CITY OF ALBUQUERQUE

September 28, 2018

**RE: Signal Village Subdivision
Signal and Ventura NE
Grading Plan Stamp Date: 9/10/18
Drainage Report Stamp Date: 9/10/18
Hydrology File: C20D078**

3 OF 5

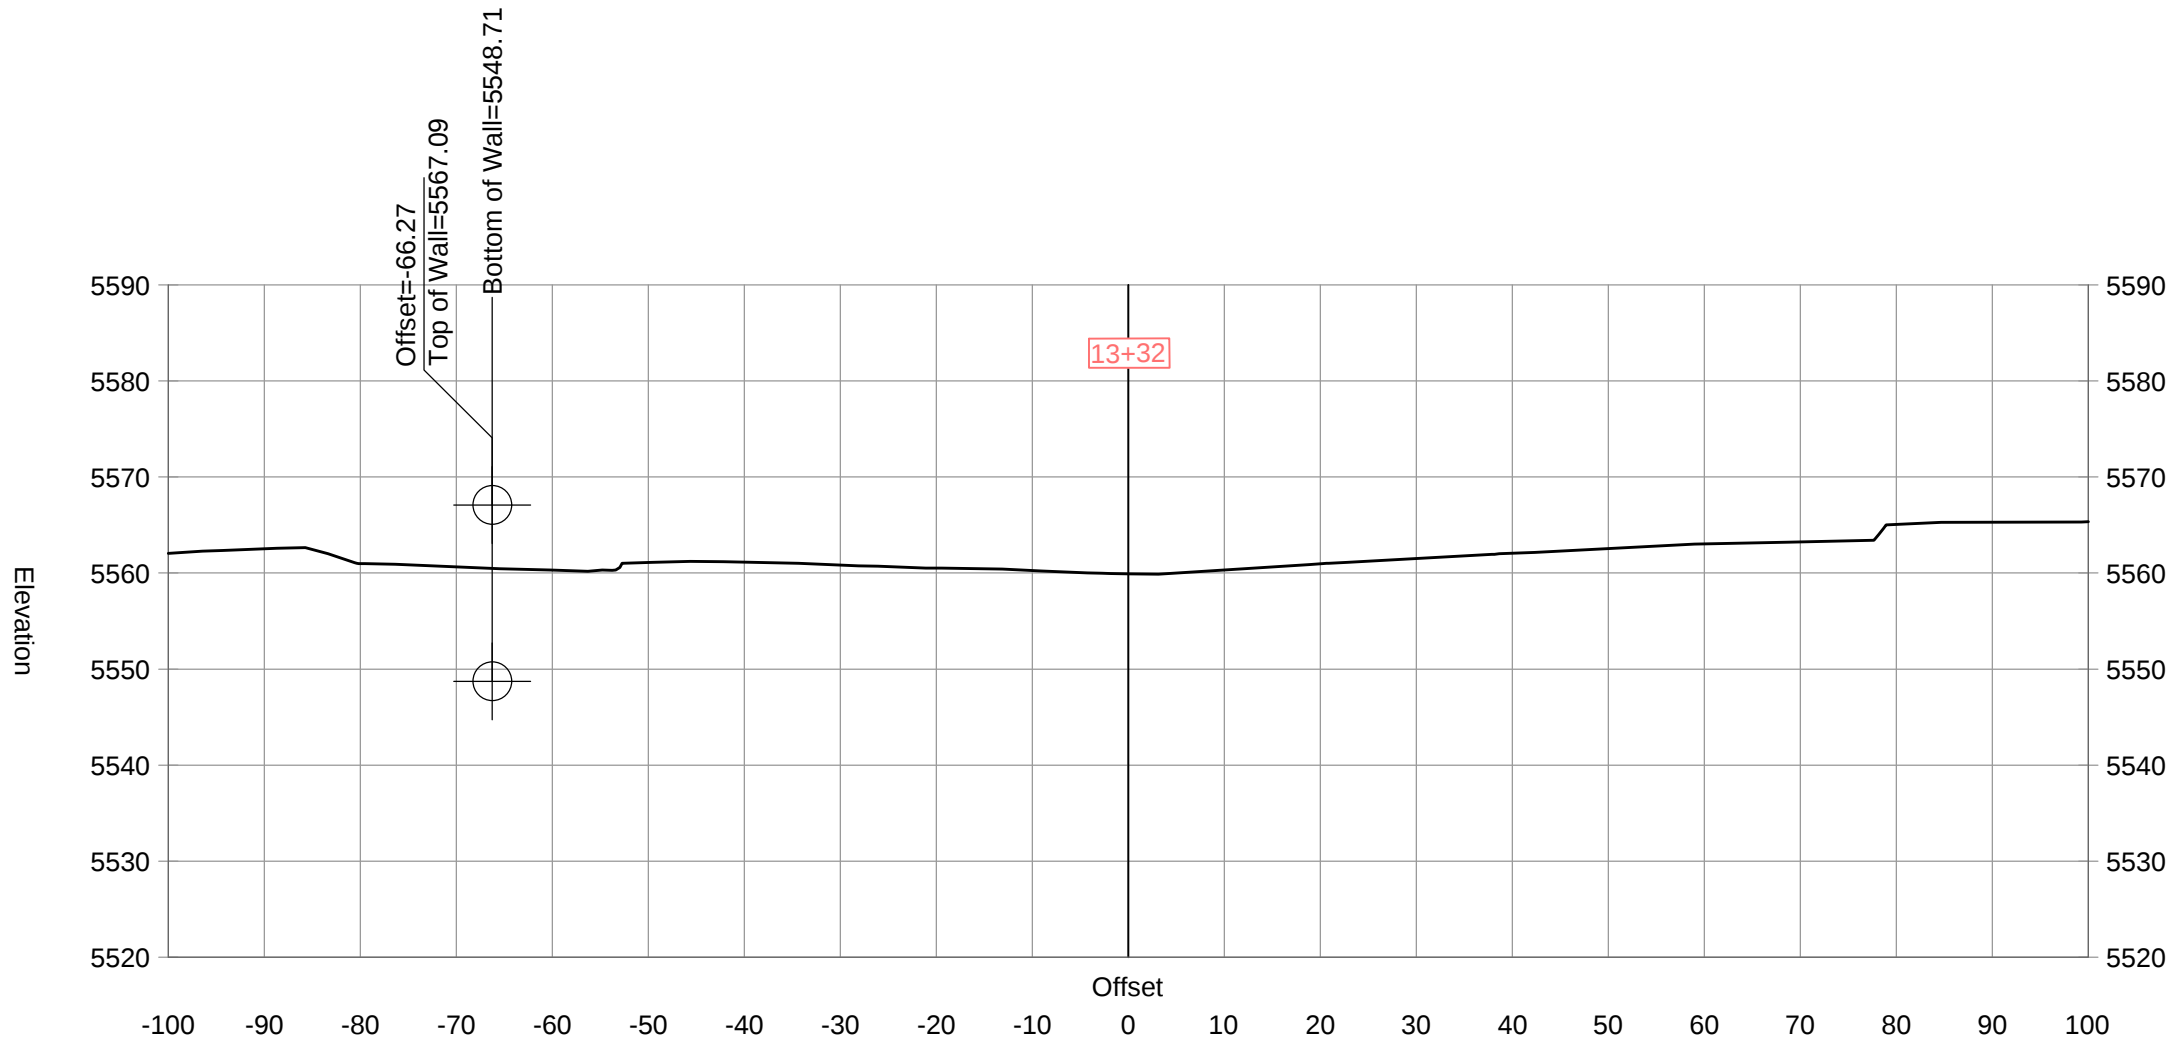
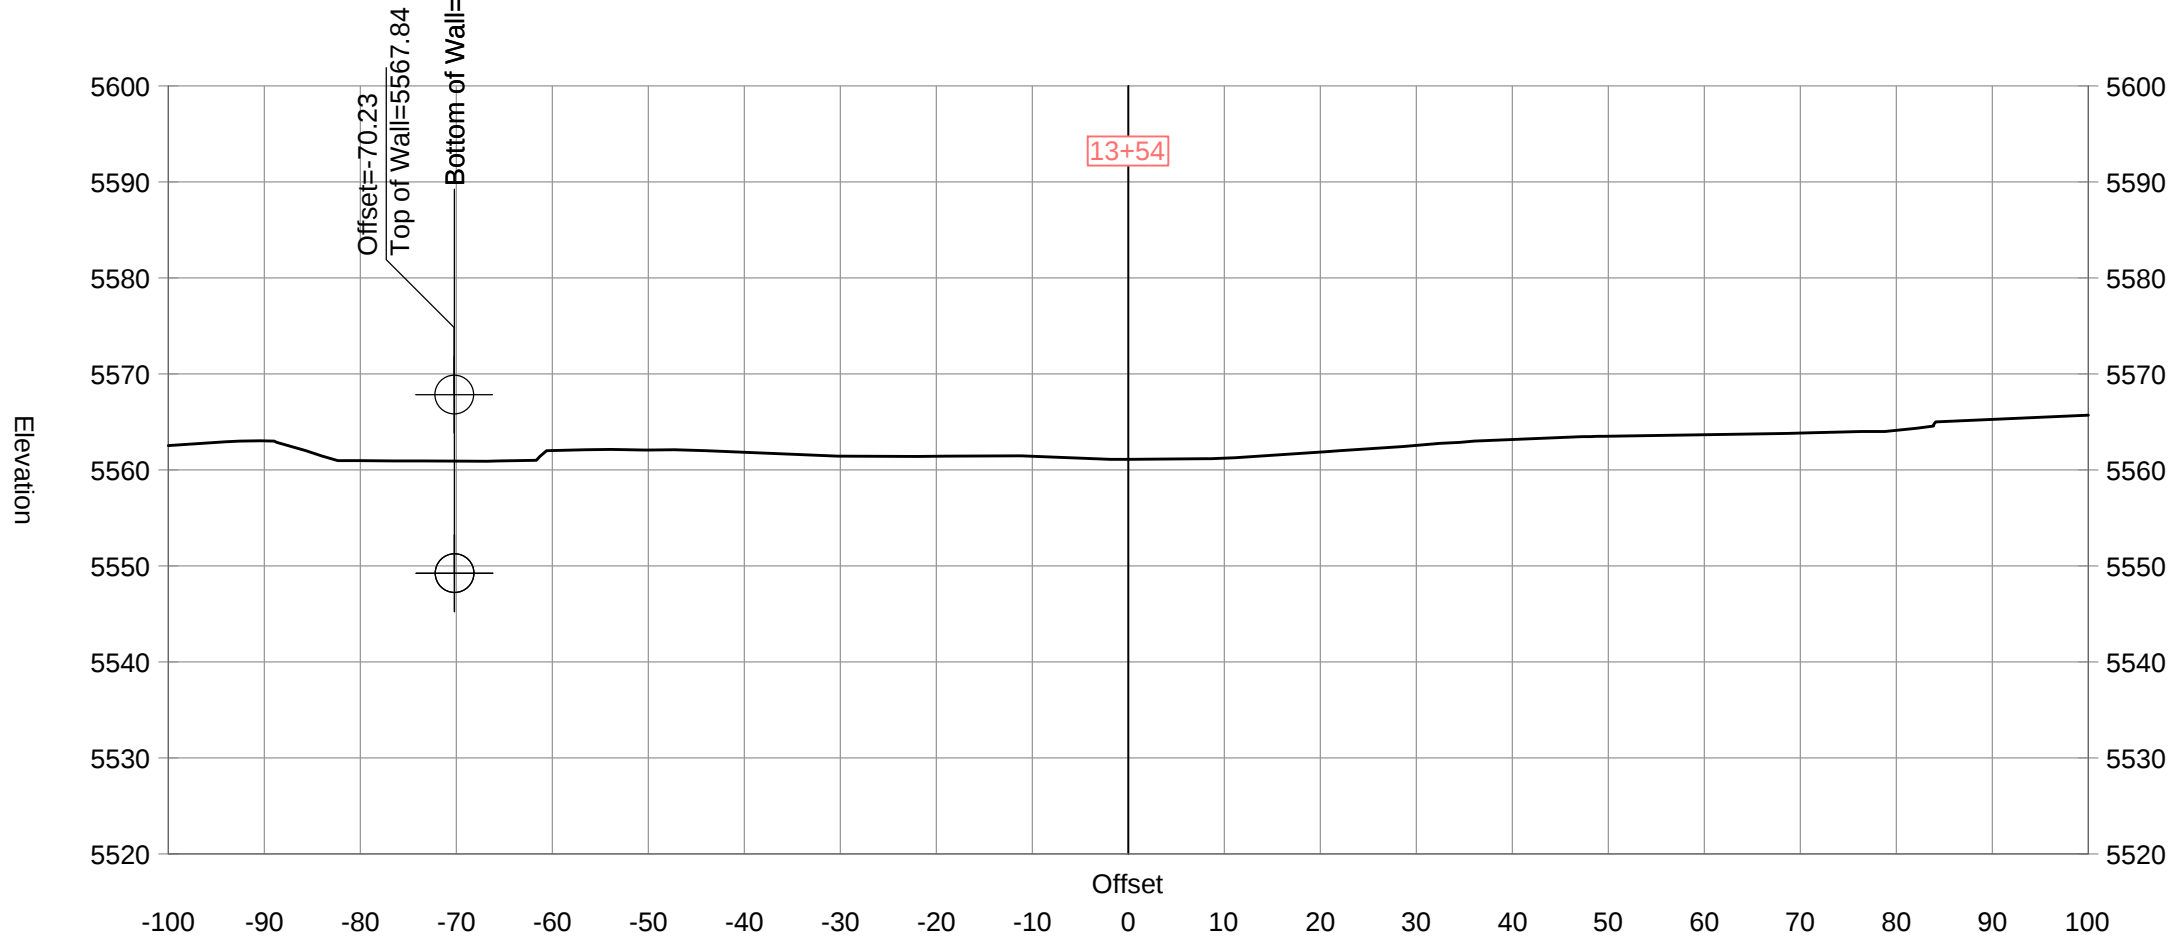
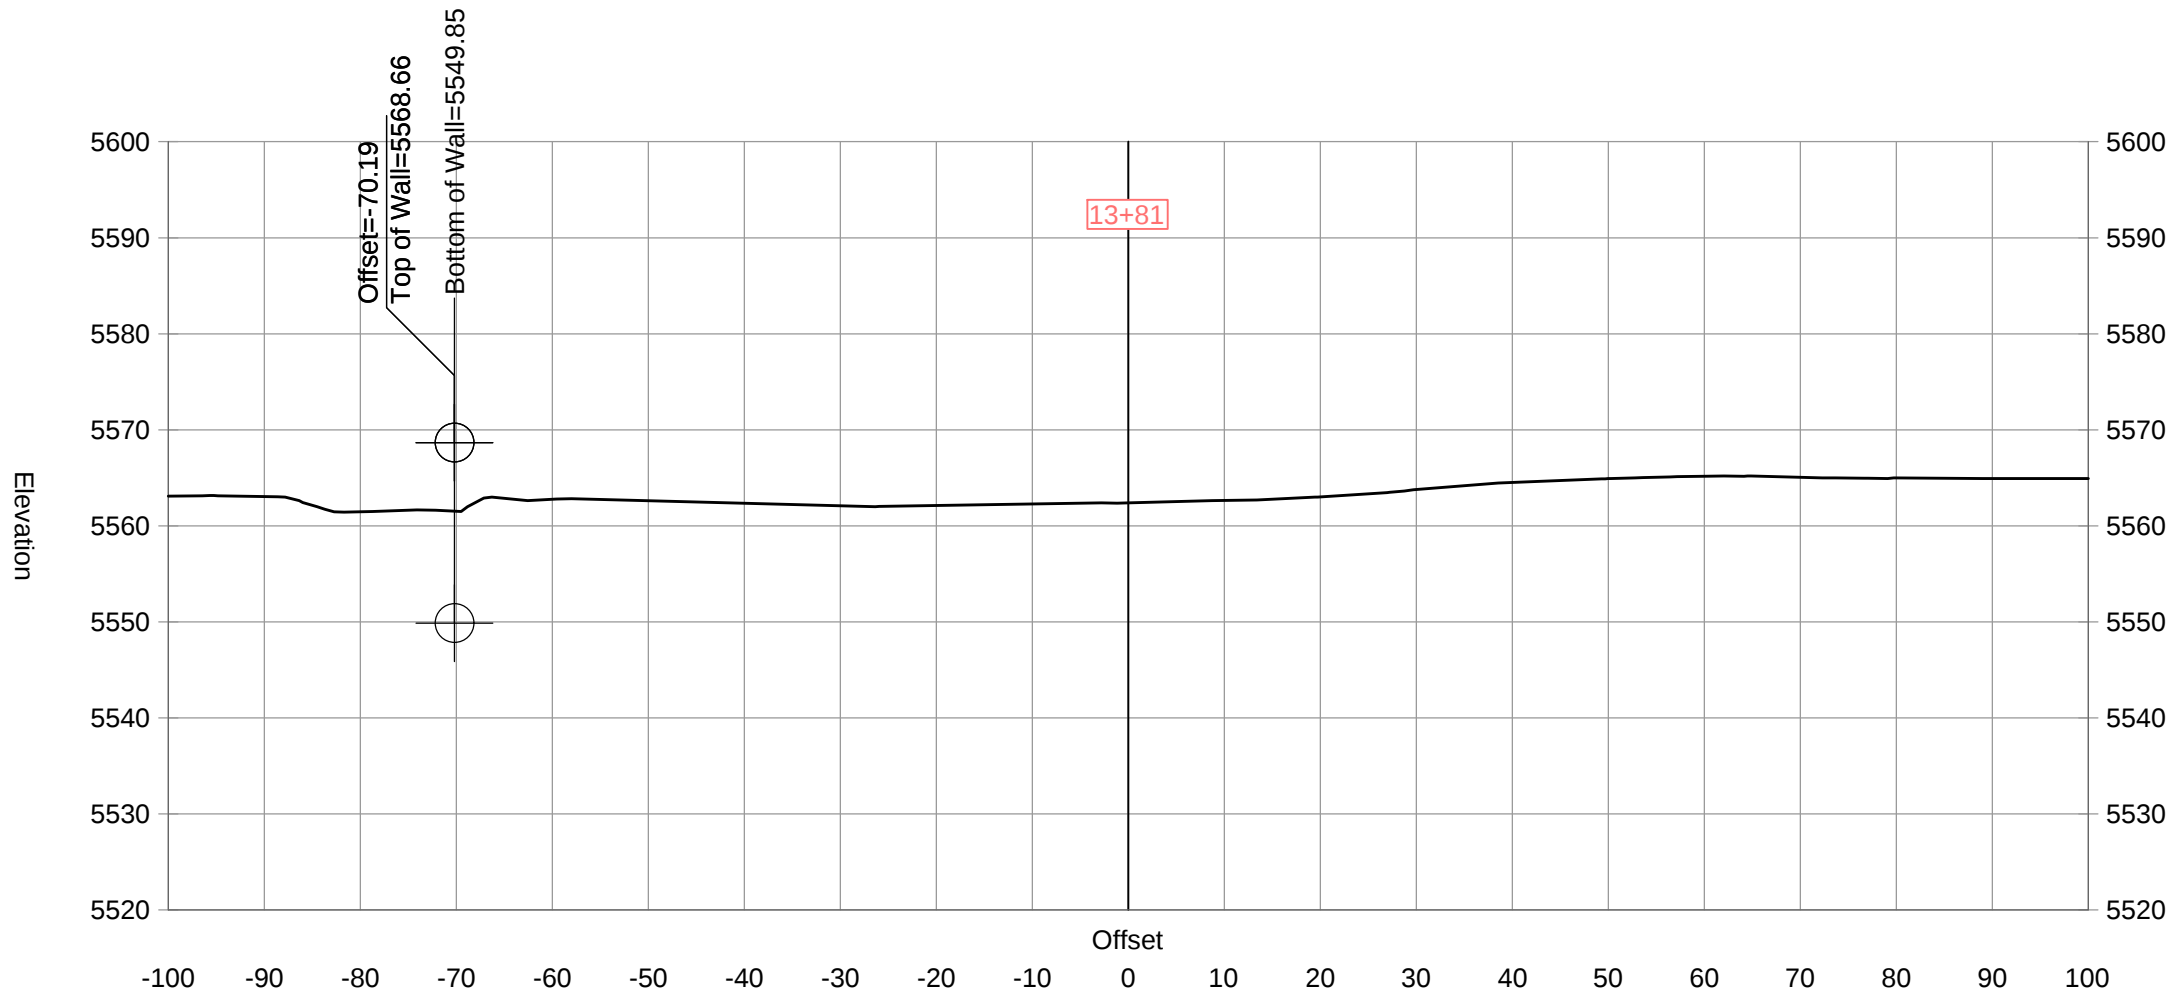
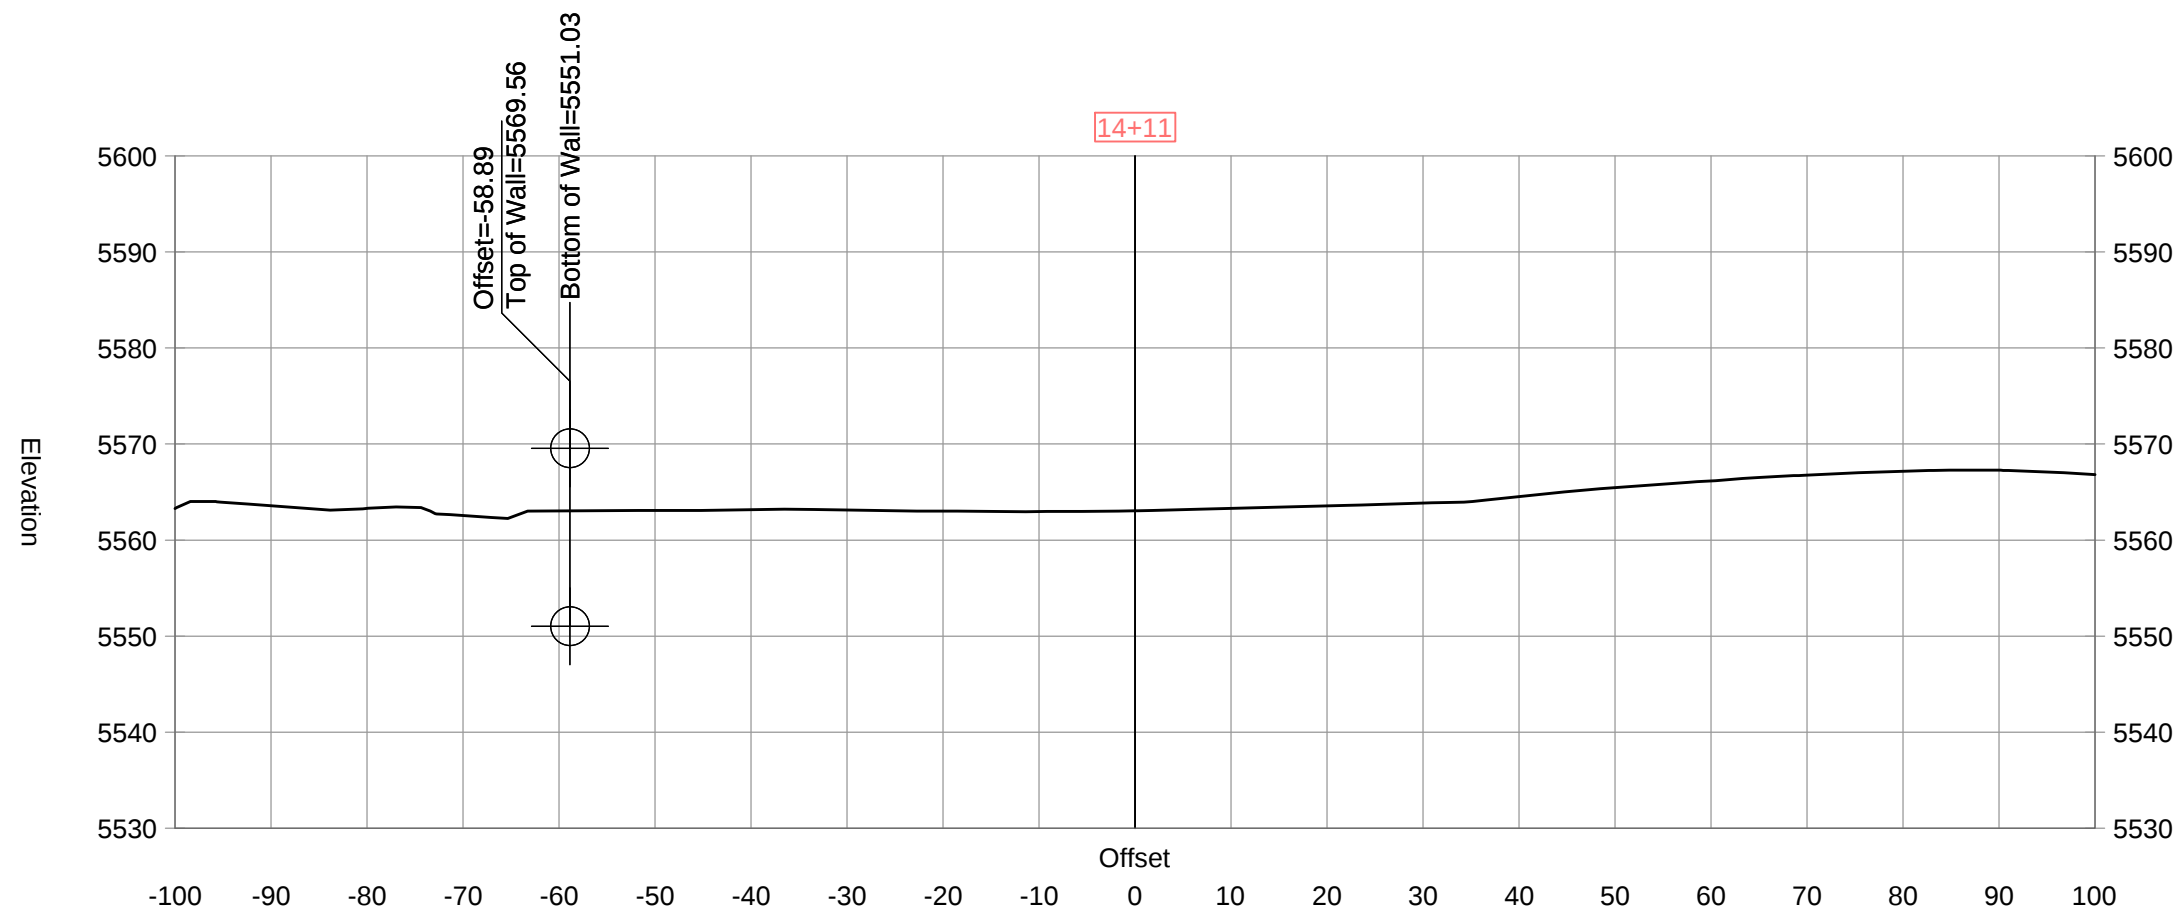
1. Show all infrastructure improvements on the grading plan, especially curb and gutter and sidewalk on Ventura. The return is not in the correct location at Signal/Ventura intersection. Ventura improvements must include curb and gutter and sidewalk and ½ section collector paving section for the full length of frontage. These improvements provide adequate protection from scour so a scour wall is not required on the east side of the project. Dimension face-to-face of curb, and sidewalks on both sides of the centerline. Show connections and transitions to the existing curb and pavement on Signal.

2. Show and label the existing and proposed contours, including all proposed grading both onsite and offsite and label limits of grading. Extend limits of existing topo to include the ROW on Ventura, south of the Ventura/Signal intersection; include curb returns.

3. Provide additional details for the first flush pond; show the water surface elevations for both the first flush volume and the 100-yr volume. Include supporting calculation for the overflow channel as well (Both the overflow channel and the pond will need to be dedicated as private drainage easements on the Plat). Correct notes on the grading and drainage plan under *Developed Drainage Condition* to describe the central first flush pond and its overflow north to the arroyo, not south to Signal.

4. Typical sections are required at all retaining walls (not just the scour wall) at the point of maximum retainage showing existing ground, proposed grades, lot lines, and dimensions.

11. The scour wall is shown as being constructed from CMU block which is constructed in level runs, but the profile shows the scour wall as sloping along its length. The location of the steps should be called out on the plan for the footer and top of wall.

12. The footing of the scour wall looks too small. It has to support the wall after the soil is removed from the low side to the scour depth. Provide structural calculations including loading assumptions.
